Consultation Response from KC, Conservation and Design
2020/93308 Former Spotted Cow Pub, New Hey Road, Huddersfield, HD3 4BU
Erection of an A1 foodstore with associated parking, servicing areas and landscaping
Date Responded: 21/12/20 | Responding Officer: Craig McHugh | Responding Ref: HUD 26/962
Summary

DRAWING TITLE  
**Overland Flood Flow Route**

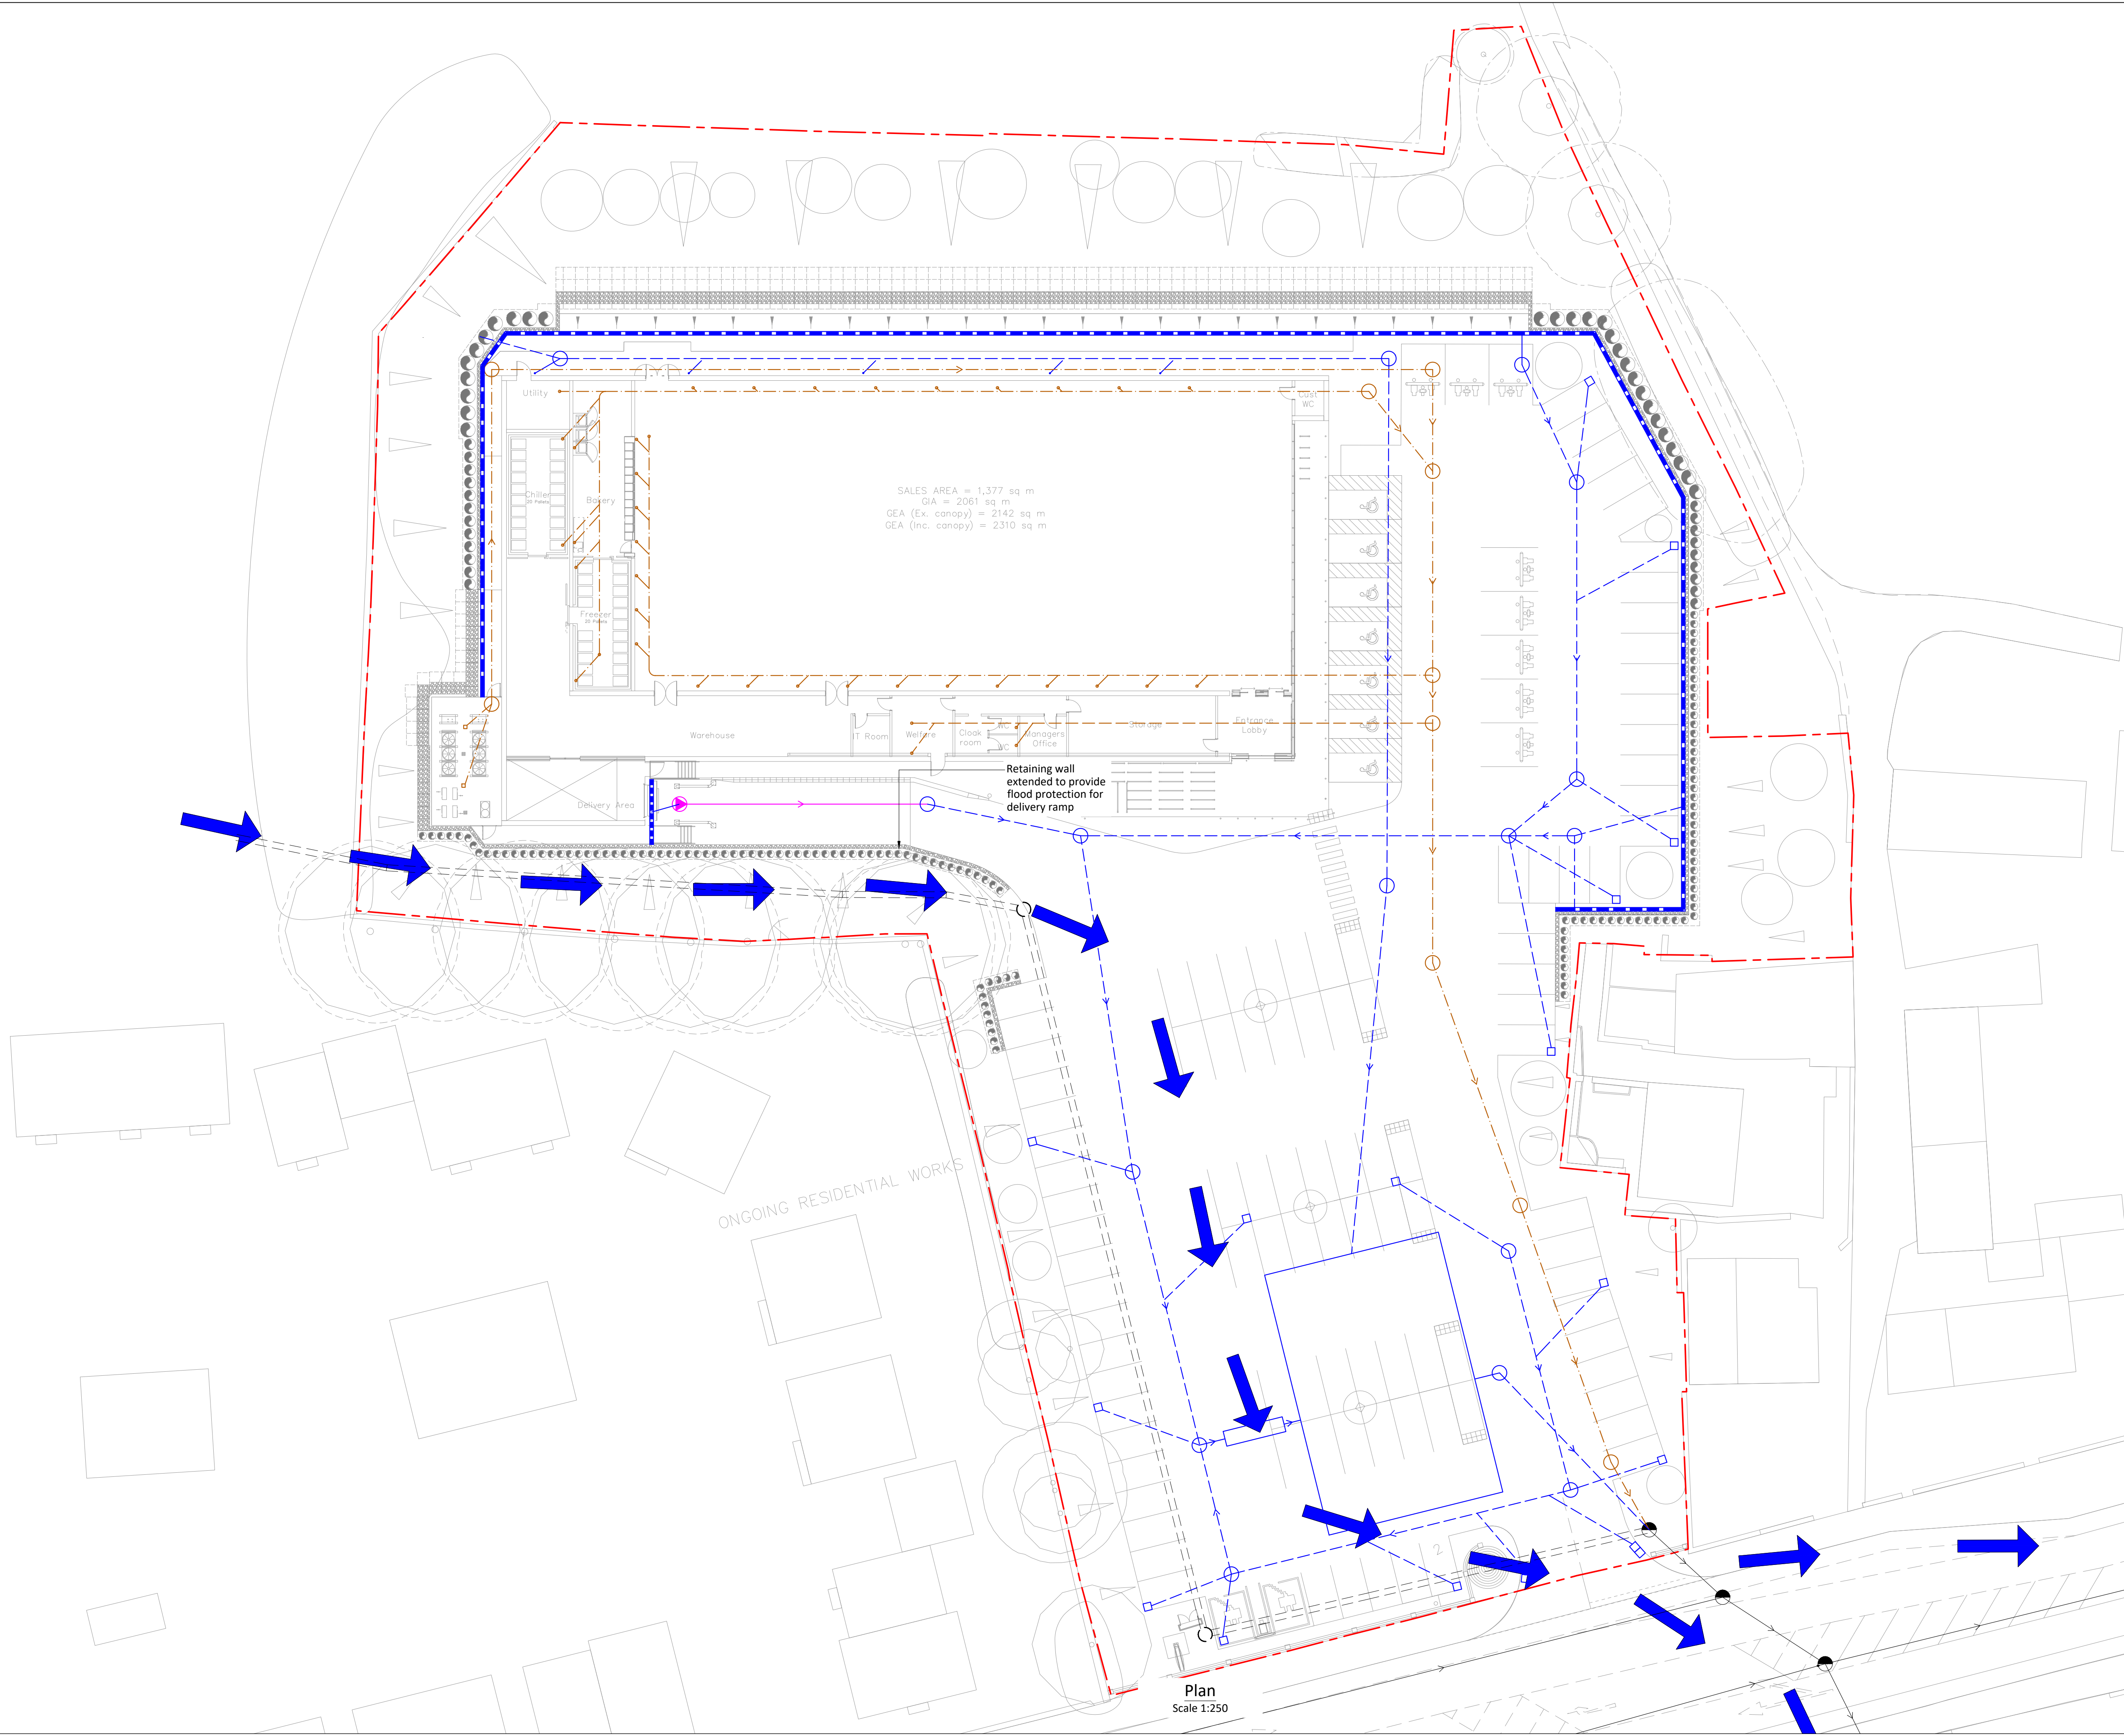
Of particular concern is the scale of the retaining structures necessary to enable the development and the manmade stepped profile they would create. In places this would be 2-3m above existing ground levels and topped by a 1.5m timber fence. The submitted Heritage Impact Assessment does not consider the impact of this retaining structure on the setting of the affected heritage assets, which as the elevations (Proposed Retaining Wall Elevations Drawing P406) show will in places be much higher than the building itself.. The existing grey site fencing is obtrusive in the setting of both Salendine Nook Baptist Church and 390 and 398 New Hey Road and this is sited on current ground levels. The retaining structure will also impact on the local townscape of New Hey Road and dominate the environment in the car park below them.

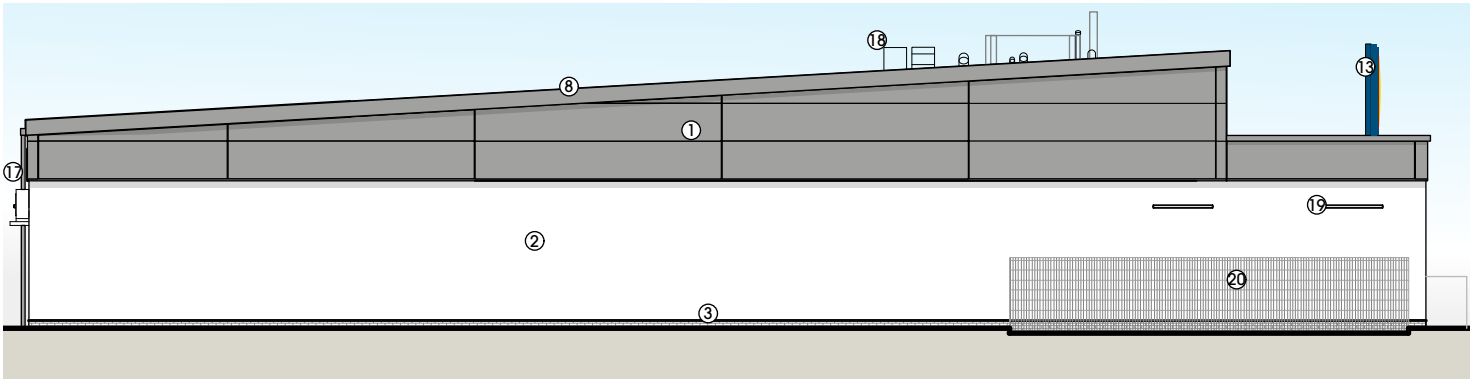
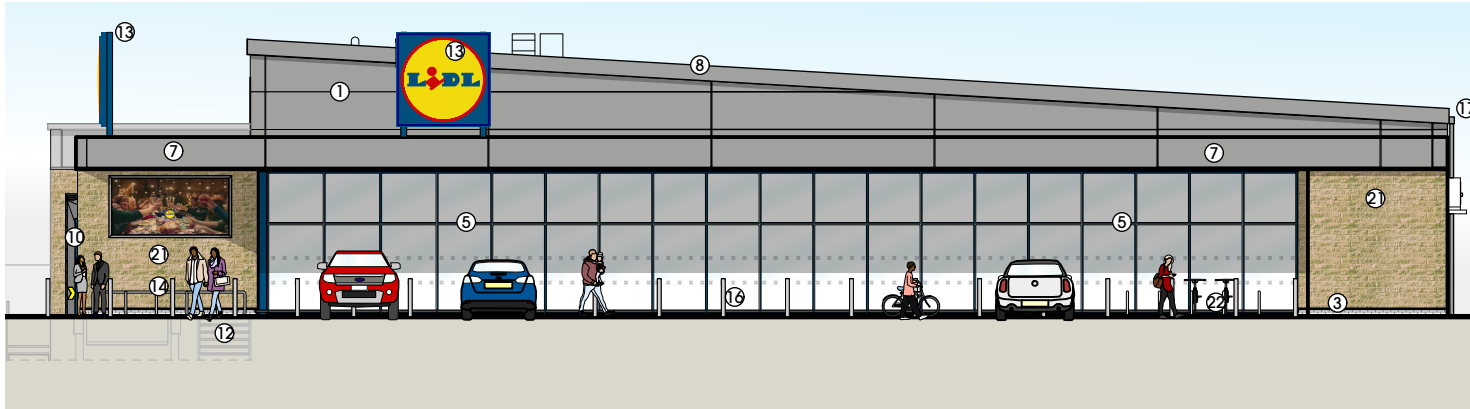
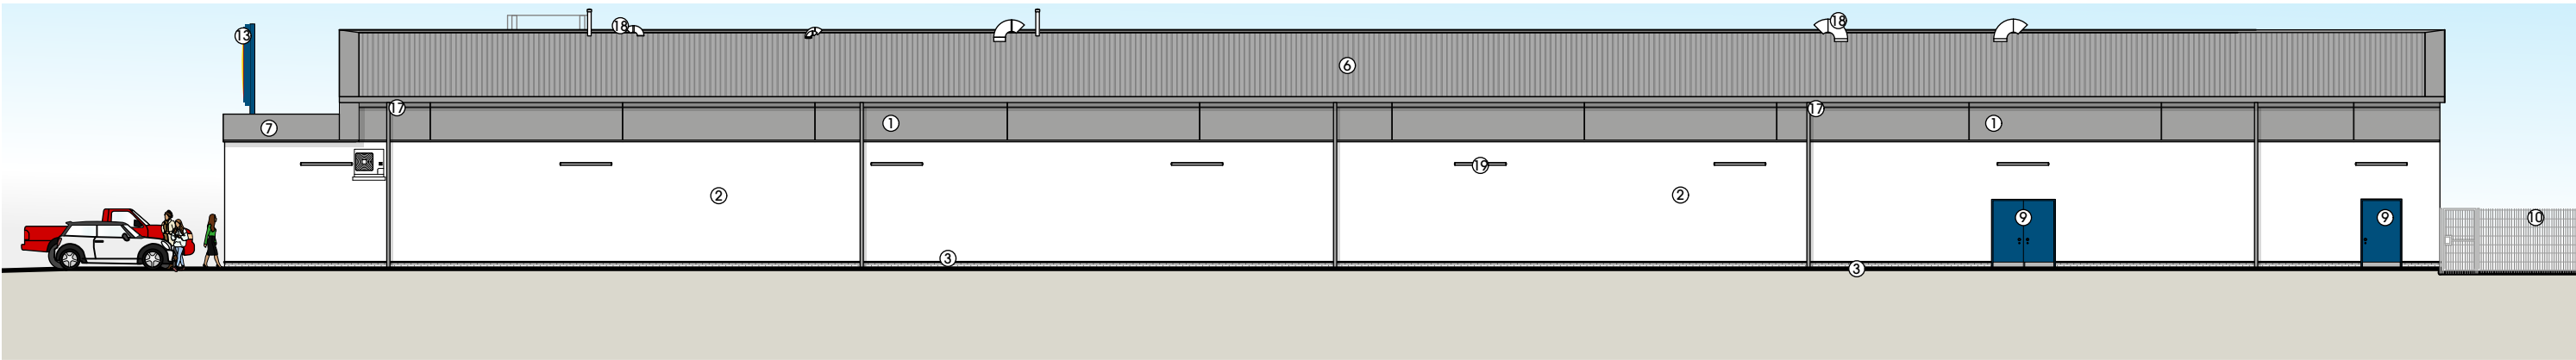
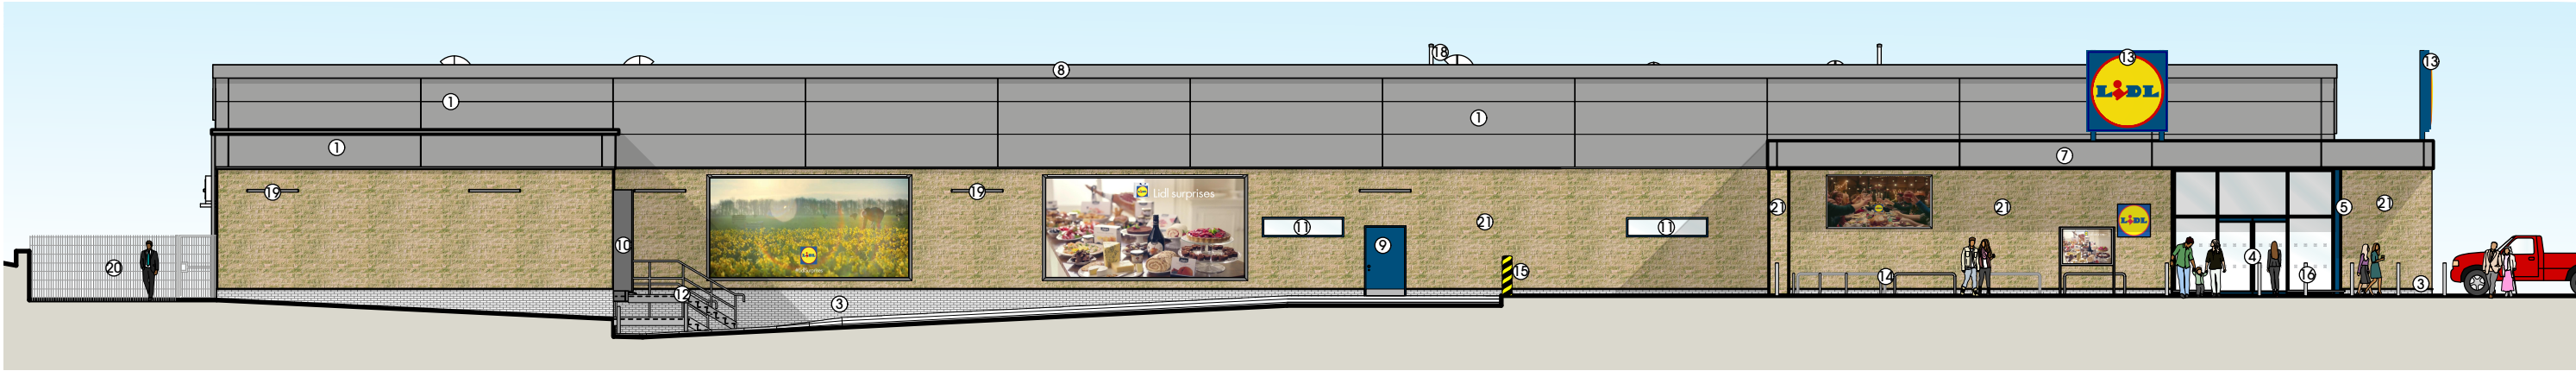
The development would be a large slab building set within a substantial retaining structure with a hard-landscaped car park to the front. It would be detailed with large expanses of glazing, white render, grey cladding and a 6m flagpole advertisement. This would not respect or enhance the character of the existing townscape. The scale of the engineering operations necessary to carry out the development would entail environmental impacts that could not be considered highly sustainable.

The development would not respect the grain, scale, form, and details of surrounding development and would be a prominent commercial building in the surrounding townscape, which has a strong residential character. It would create a large hard surfaced void in the townscape, where building lines close to the street and green open spaces are characteristic. The building would be one large slab, where finer grained development and small footprints are predominant. Large expanses of glazing, white render, grey cladding and a 6m flagpole advertisement would be introduced, where no similar materials or adverts are visible within the immediate surroundings.
